September 26, 2023

Re: PA22-044 – Olympic Vista PRD – First Final Plat Review
4128 Sunnyside Blvd. APN 29050300102200

A.F. NO. _____ SHEET 1 of 3

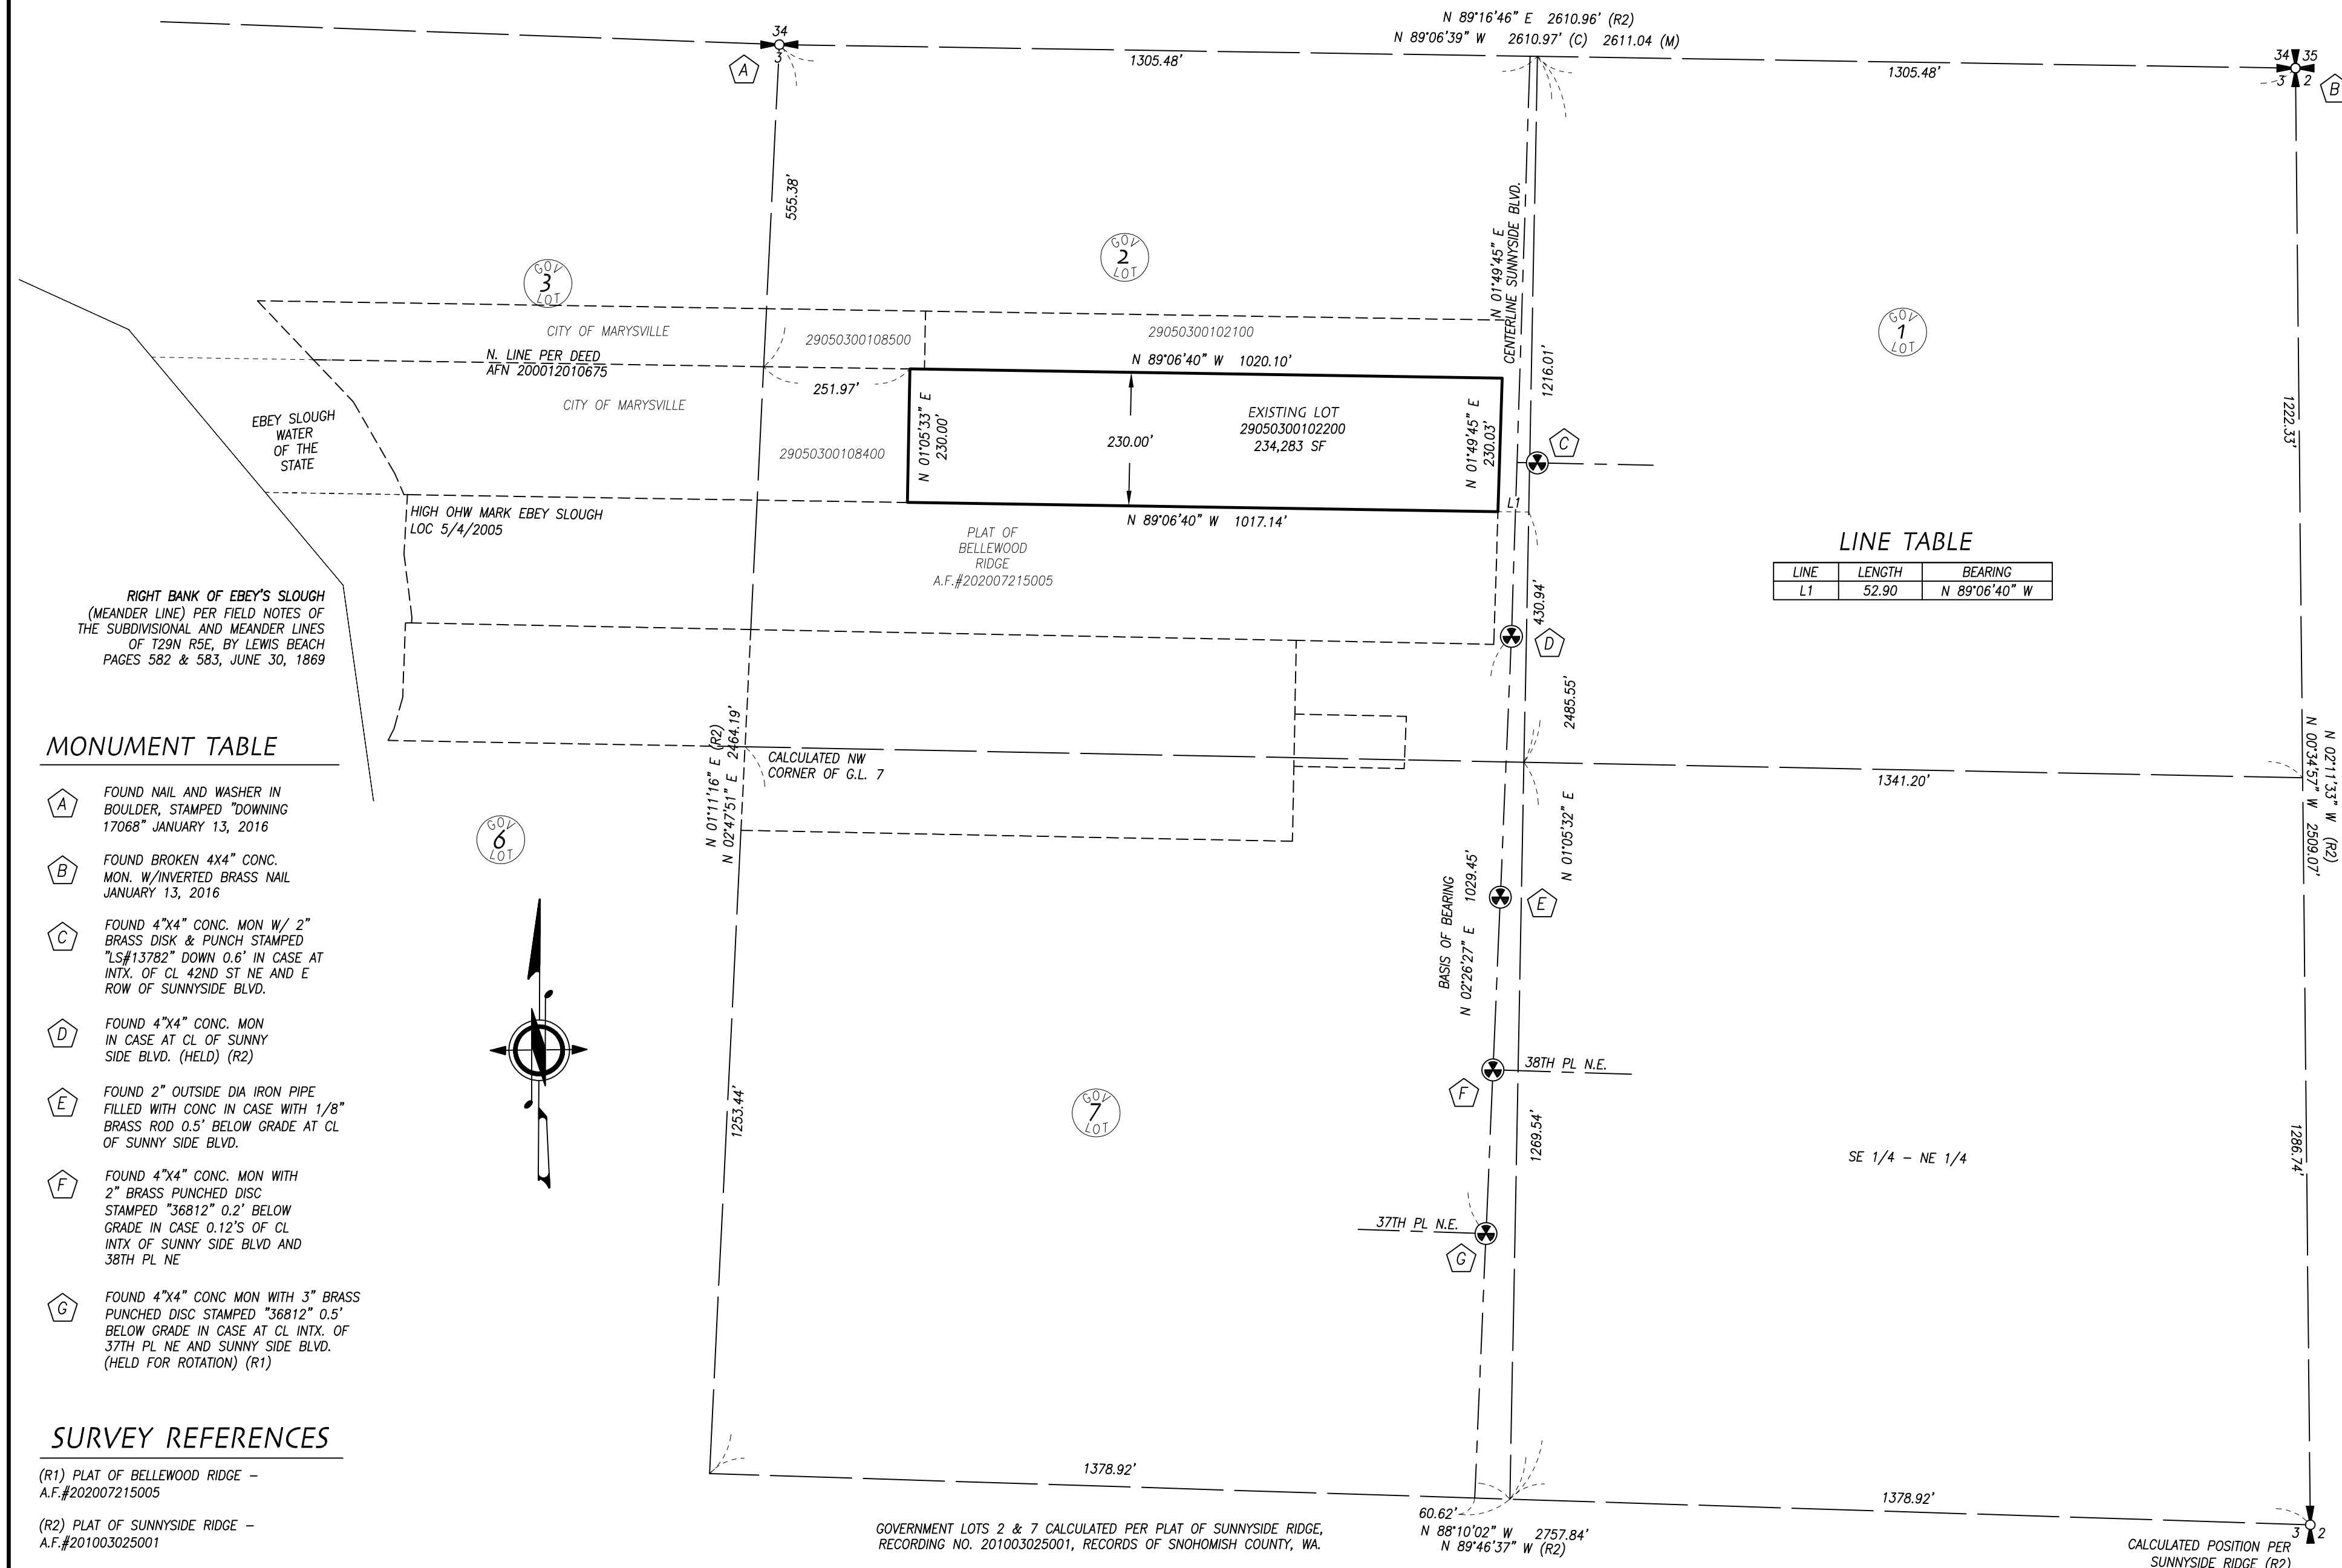
3. The legal description on the final map does not match what is on the title report and does not describe the project property. Please revise so the legal description on the map matches the description in the title report.

6. Please add the following after the second paragraph of the dedication:

That said dedication to the public shall in no way be construed to permit a right of direct access to 59th Drive from lots numbered 1 or 23 nor shall the city of Marysville or any other local governmental agency ever be required to grant a permit to build or construct an access of approach to said street from said lots.
7. Please add a restriction that traffic impact fees, in the amount of \$6,300.00 shall be paid prior to final building inspection being granted.
8. Please add a restriction prohibiting the establishment of Accessory Dwelling Units (ADU's) within the PRD.
9. Please add a restriction for the covenants, conditions and restrictions that includes a line for the Auditor's file number to be entered.

1. Please change dedication language for Tract 998 to the following:

TRACT 998, together with drainage and detention facilities, is hereby granted to The Olympic Vista Homeowner's Association (HOA) upon recording of this Plat, subject to both an emergency and routine maintenance easement granted and conveyed to the City of Marysville. Ownership and exterior maintenance of said tract consistent with the City of Marysville code shall be the responsibility of the HOA. Use of said tract is restricted to that specified in the approved final plat. The HOA and the owners of all lots within the subdivision shall comply with those City of Marysville regulations and conditions of final subdivision approval specified on the plat. In the event the HOA should be dissolved then each lot shall have an equal and undivided ownership interest in the tract. In the event that the City of Marysville shall be required to make changes to drainage or detention facilities, City rights shall be primary and hold precedence over the rights reserved by the HOA. The City may take all such acts as are reasonably required to preserve, protect, and maintain these improvements.

SHEET
3 of 3

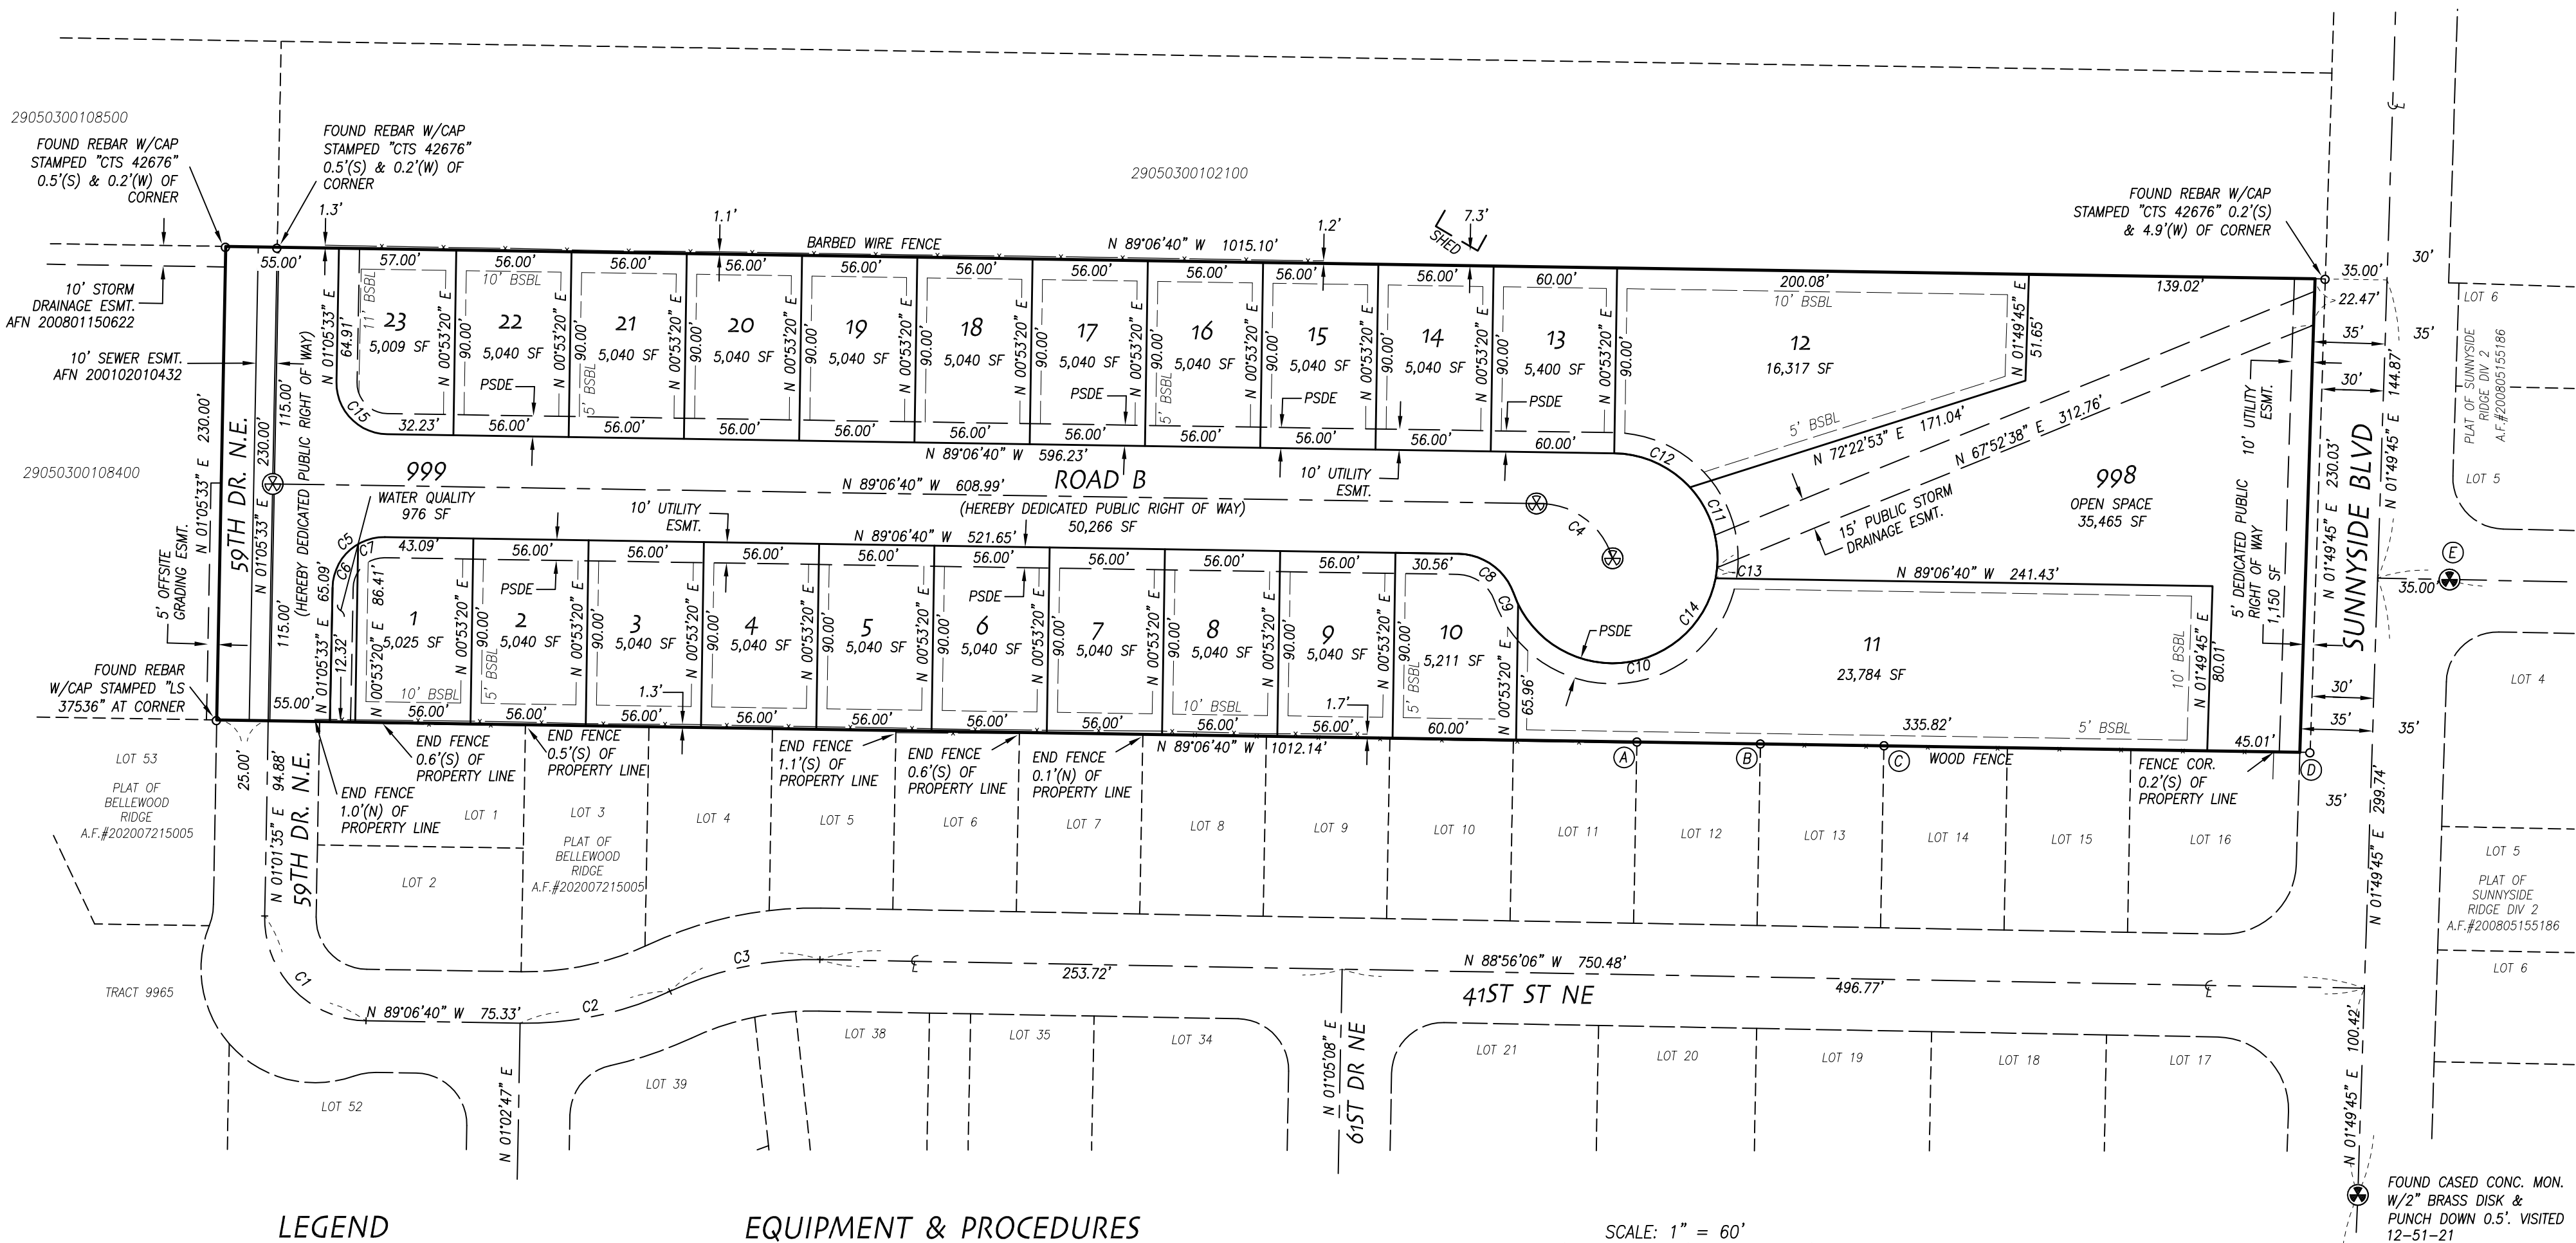
4. Please revise the building setback line on the west side of lot 1 to 10 feet.
5. Please depict lot corner monuments on all lots, as required by MMC 22G.090.780(2).

Tract 999 is proposed for water quality and to be planted with turf grass. From a functionality standpoint that should be fine. I am a little concerned that tract 999 won't be differentiated from the lot 1 yard at all. That lot doesn't really have a side yard, so the owner will probably think that grass is their lawn. Plus the HOA or lot 1 will be required to mow it, just like a park over a big vault. So it will look and feel like their yard, but they can't actually make any changes.

Language for tract maintenance and usage shall be included in the CC&R's, and the tract shall be clearly delineated from Lot 1.
